167 Fore Street – Ocean Gateway Garage Addition

April 23, 2019

Amendment

Level II Site Plan Application

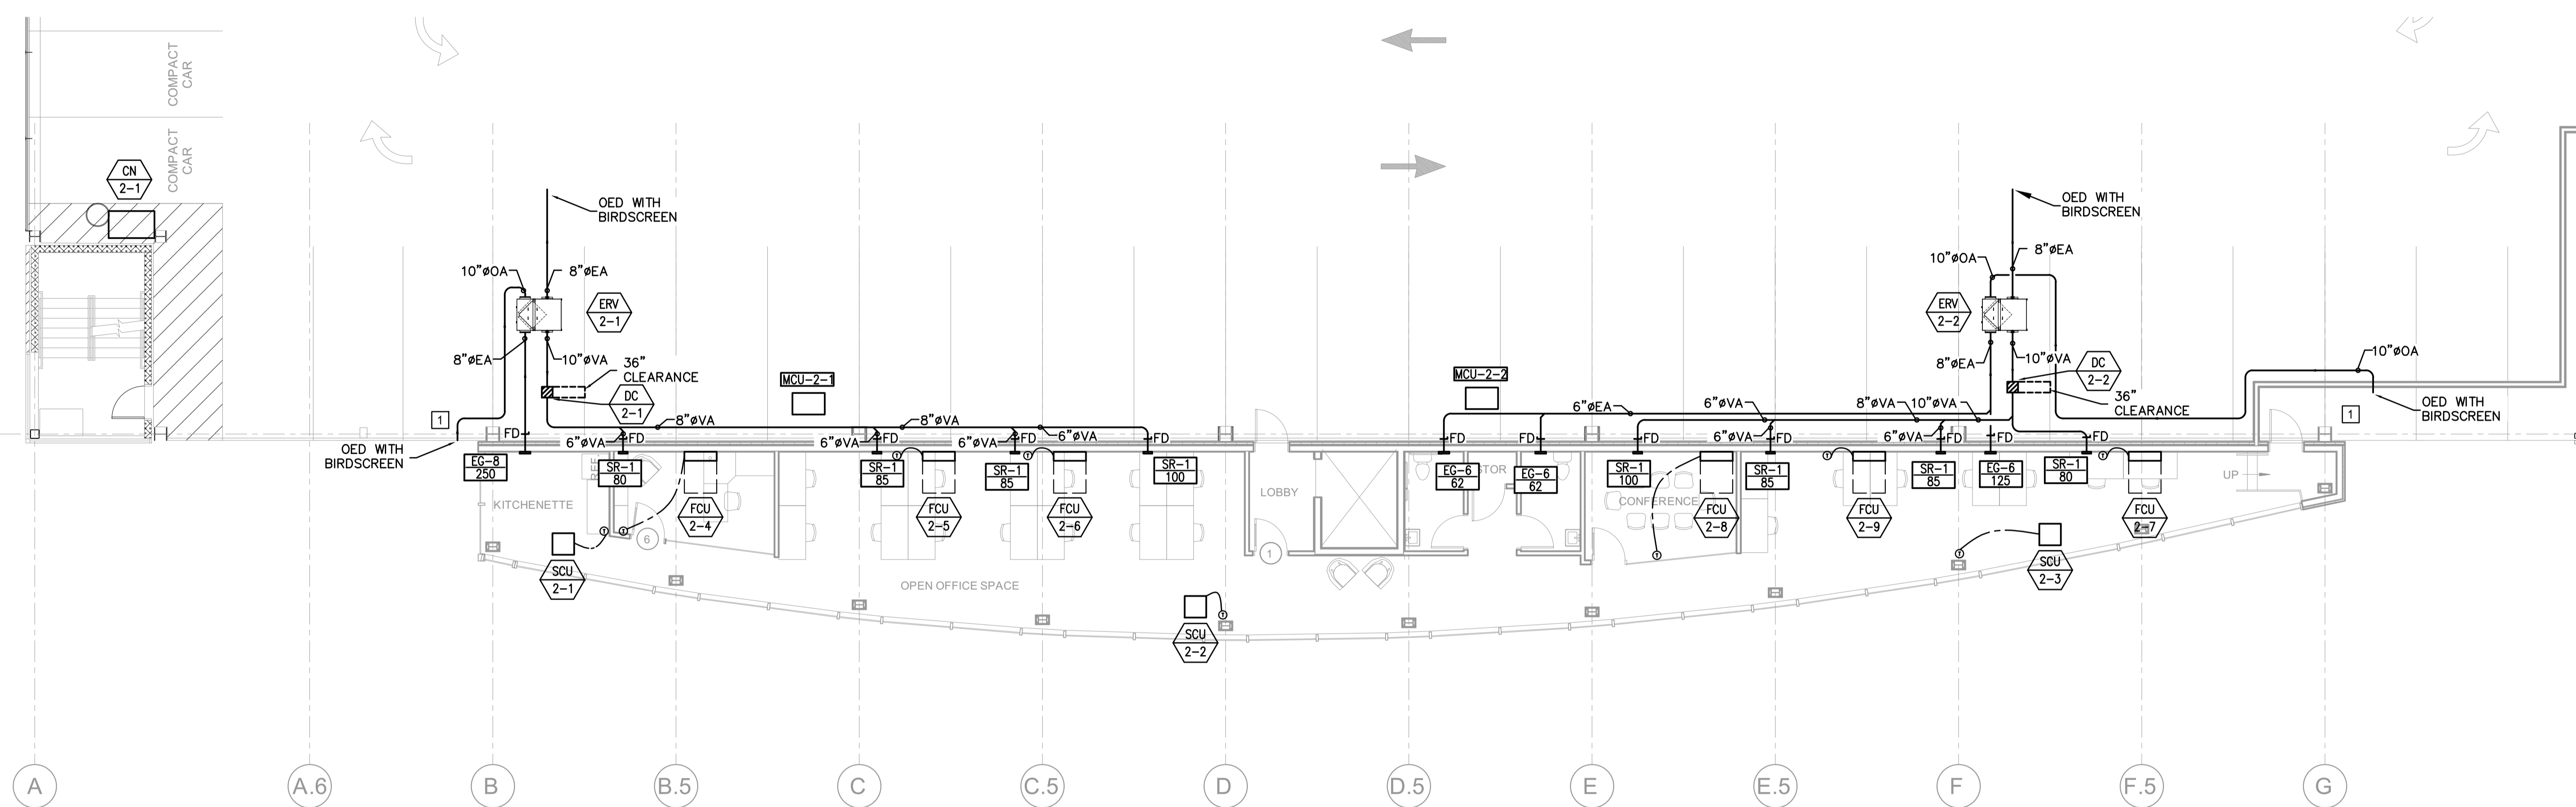
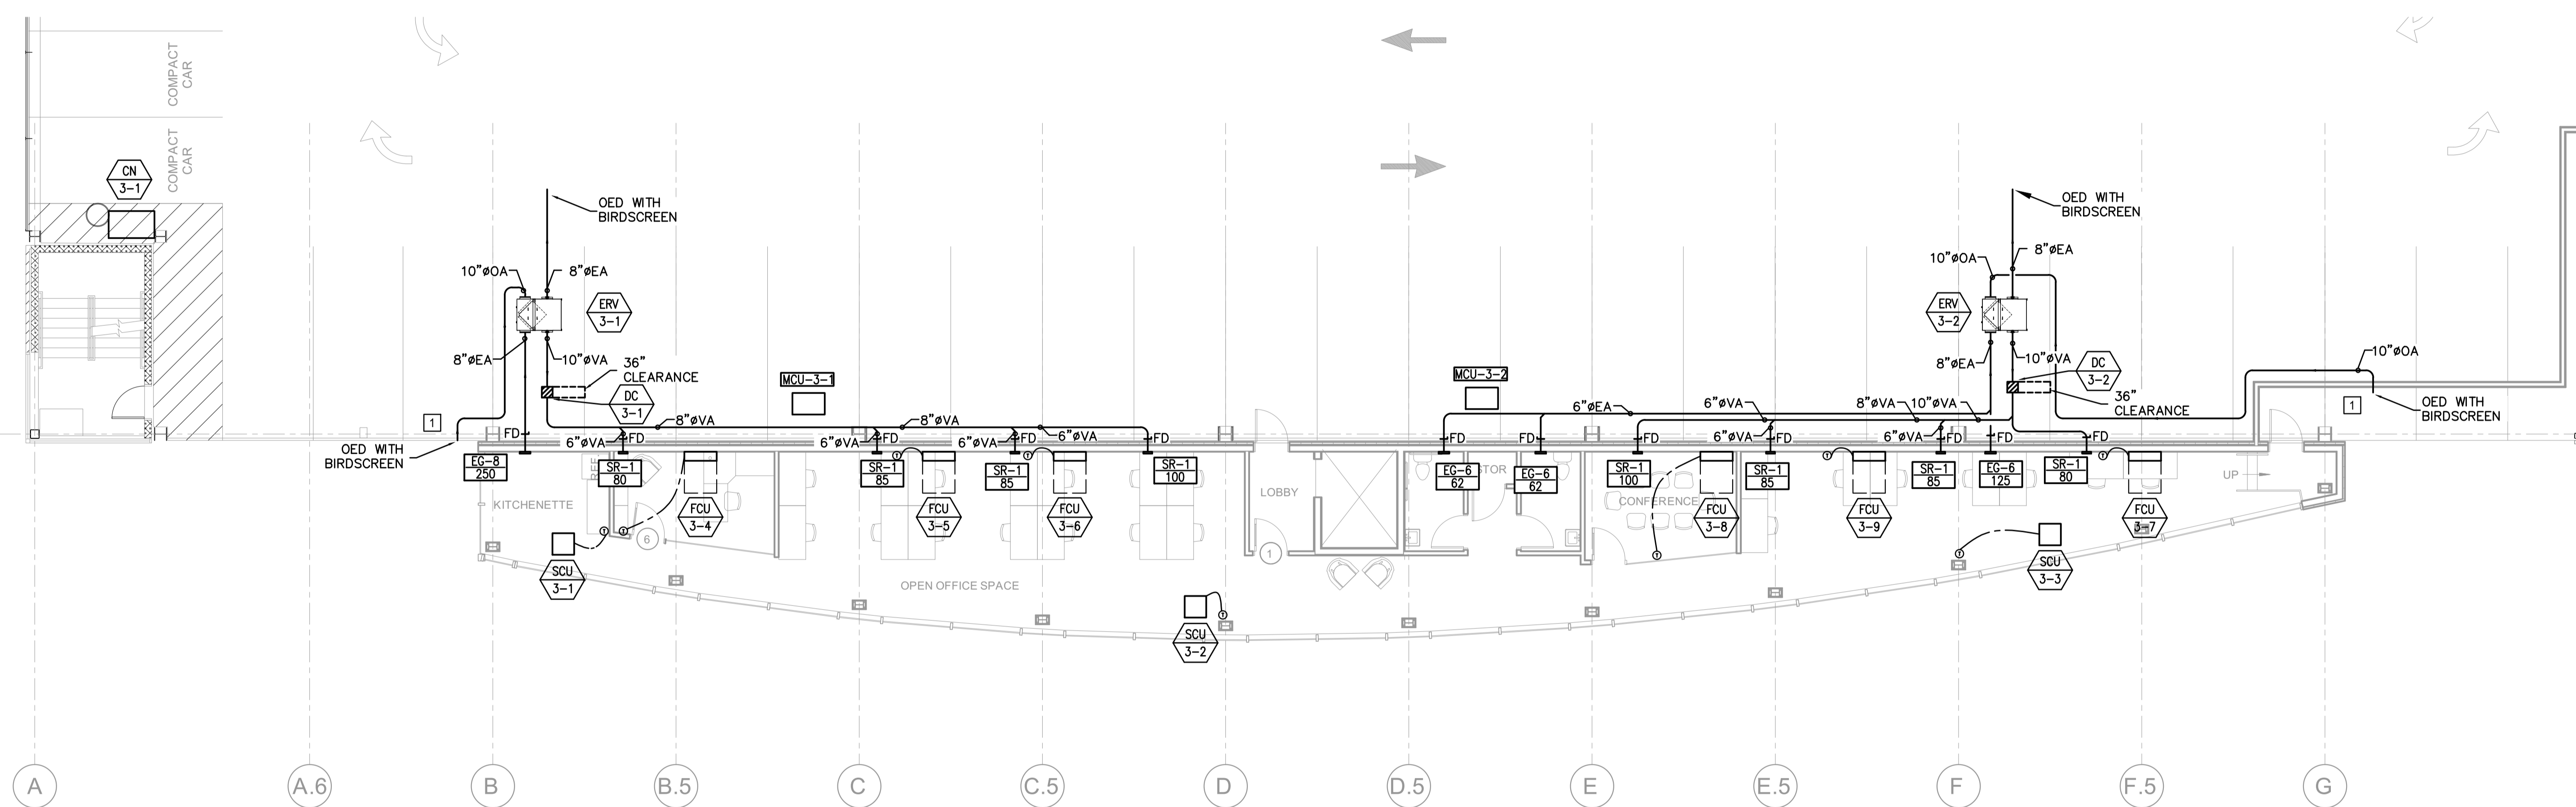
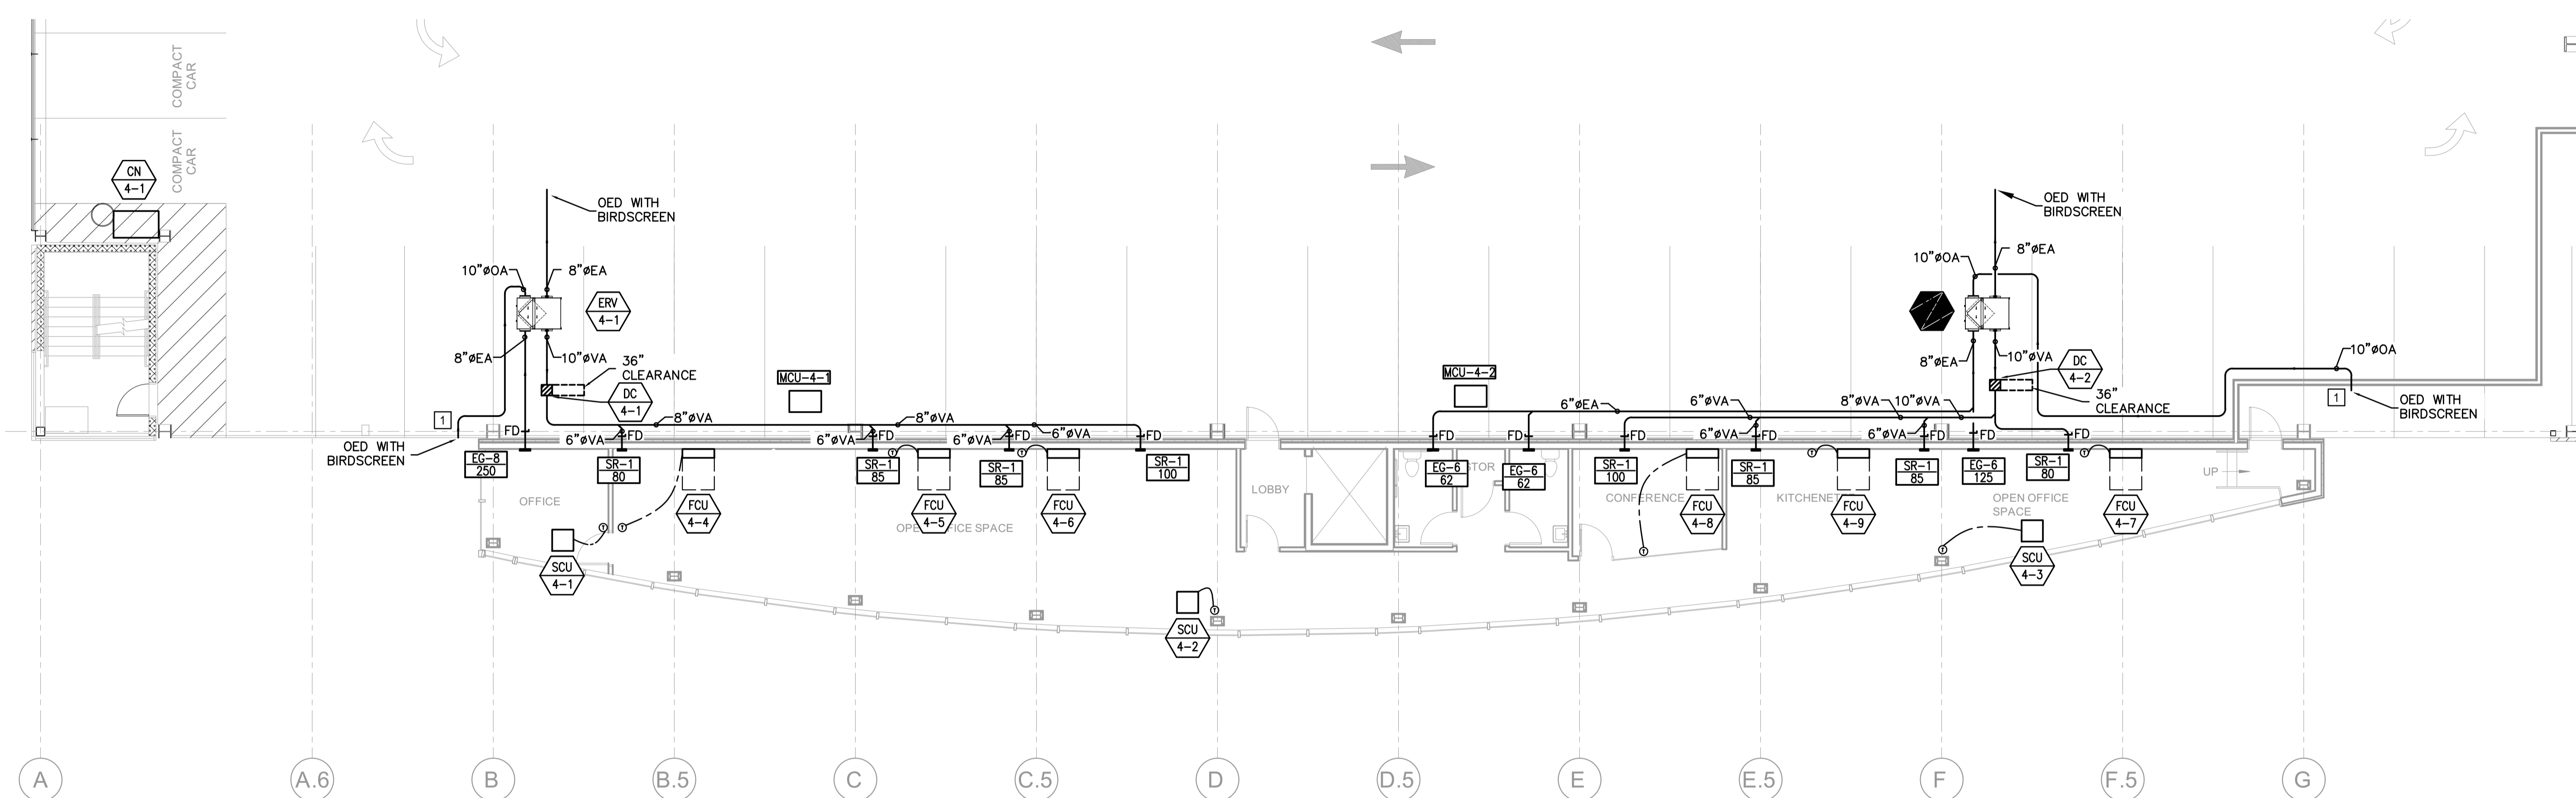
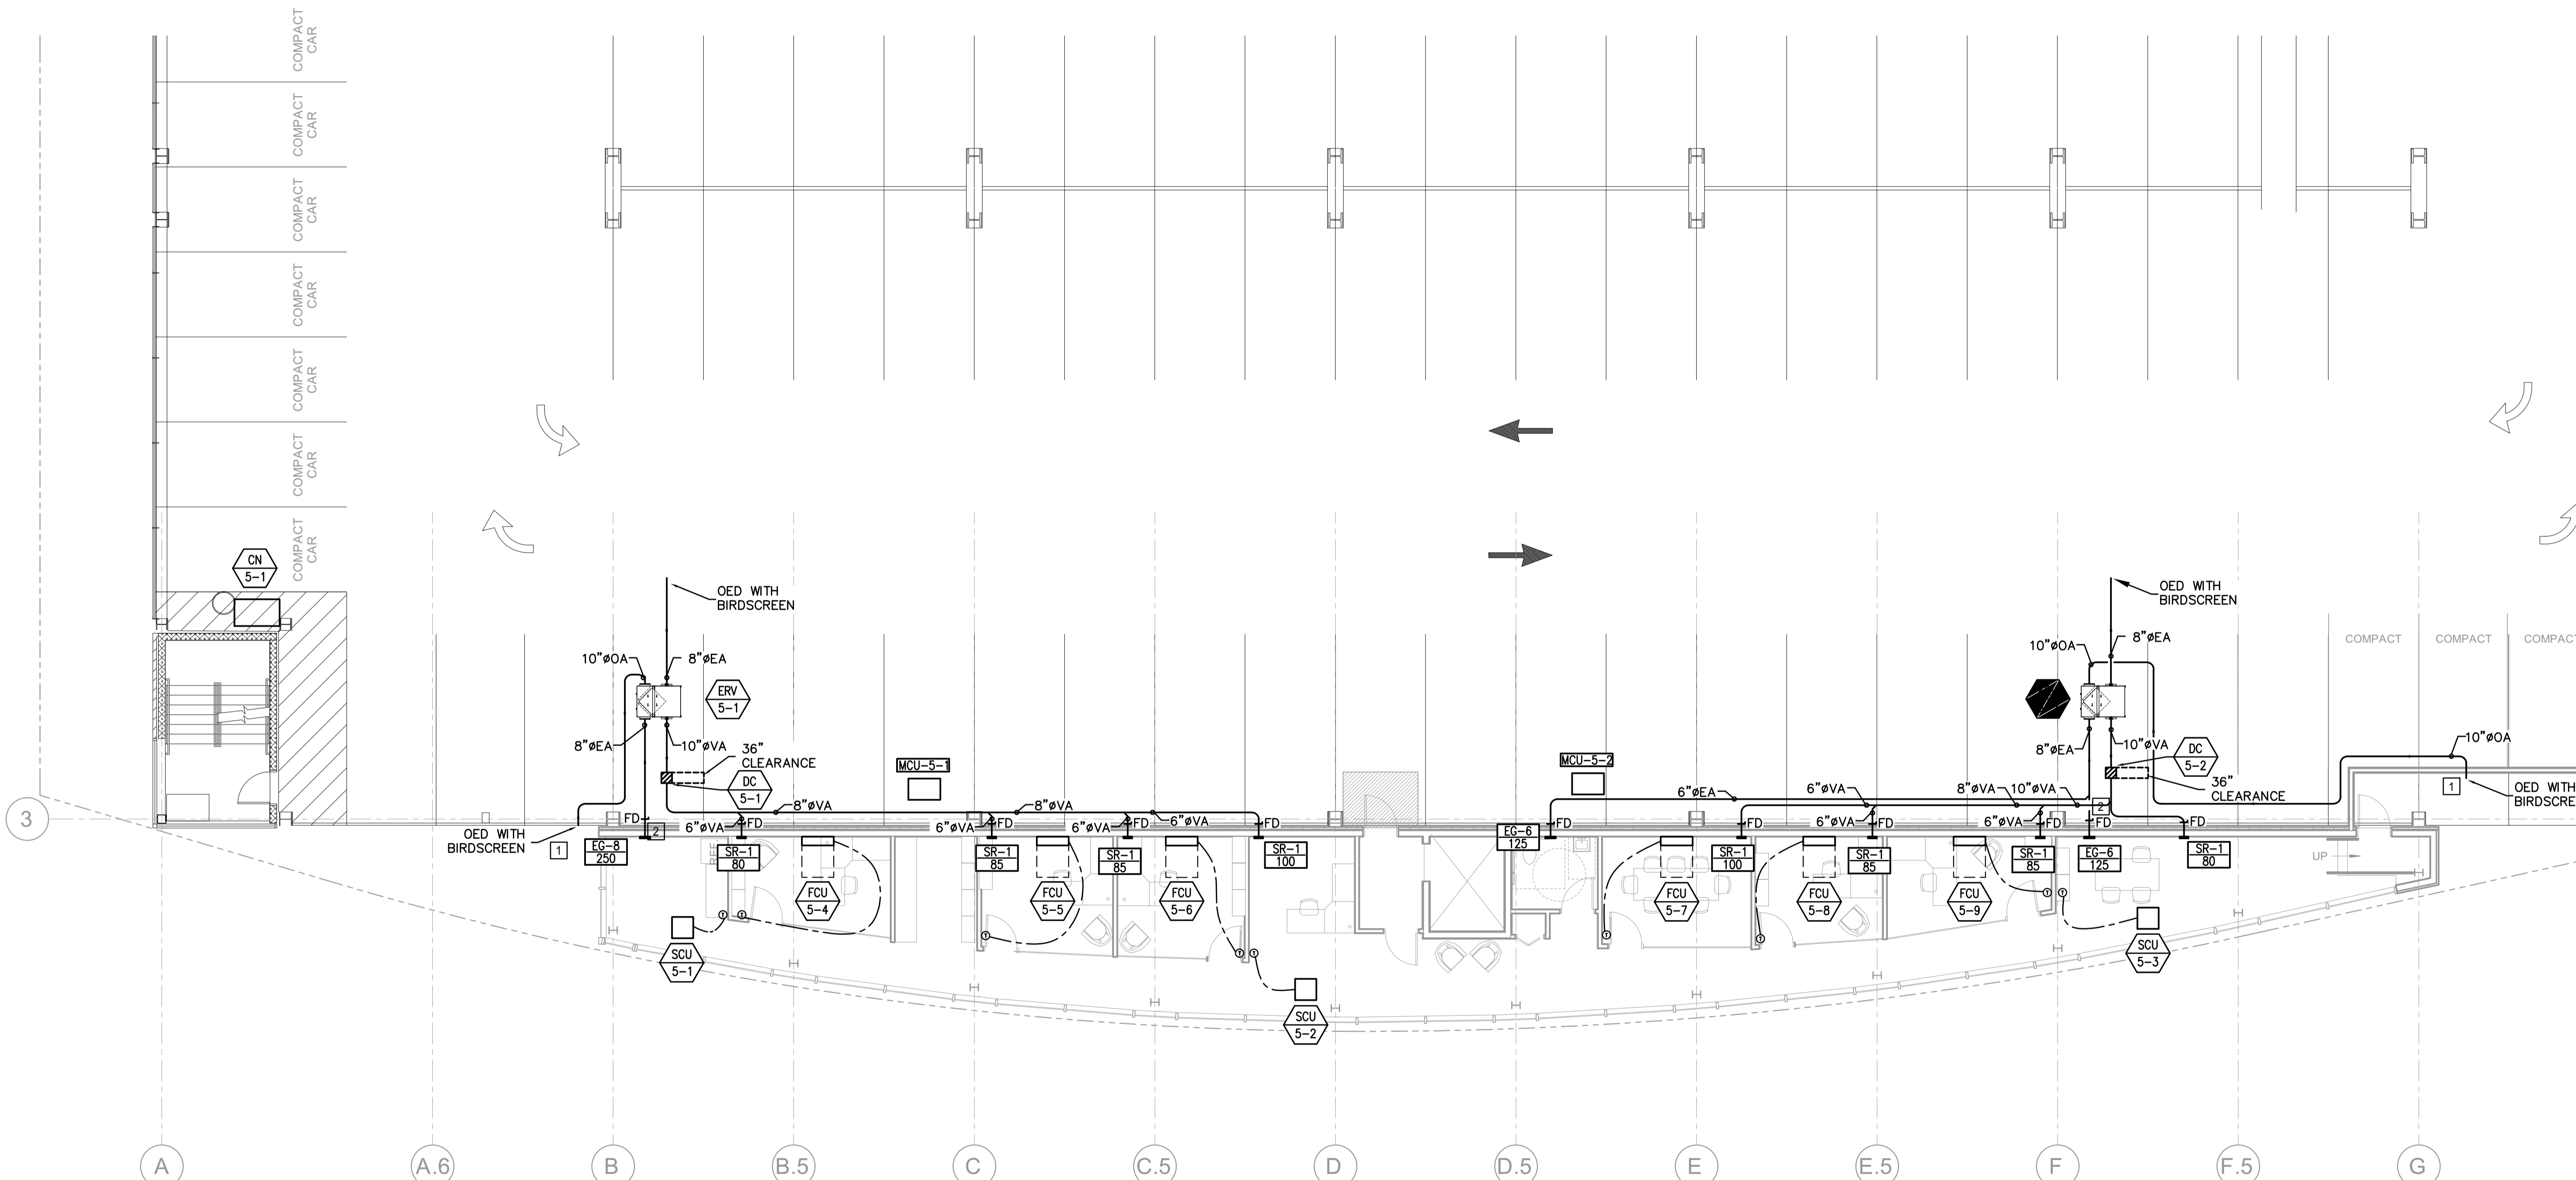
The attached plans (revised site plan and mechanical plans) demonstrate the amendment to the HVAC design as part of the original Level II Site Plan application for the Ocean Gateway Garage Addition at 167 Fore Street.

The original design intent was for the HVAC units to be located within a parking spot, typical of each level. Due to site constraints and parking requirements/lease agreements filed with the city, the location of these HVAC units was revised and resubmitted. The locations shown on the attached drawings represent the only feasible location within the existing garage layout, and all units are kept internal to the garage structure, not visible to the surrounding neighborhood.

All units are being treated and wrapped with sound attenuation material to help mitigate any sound or vibration and eliminate this concern.
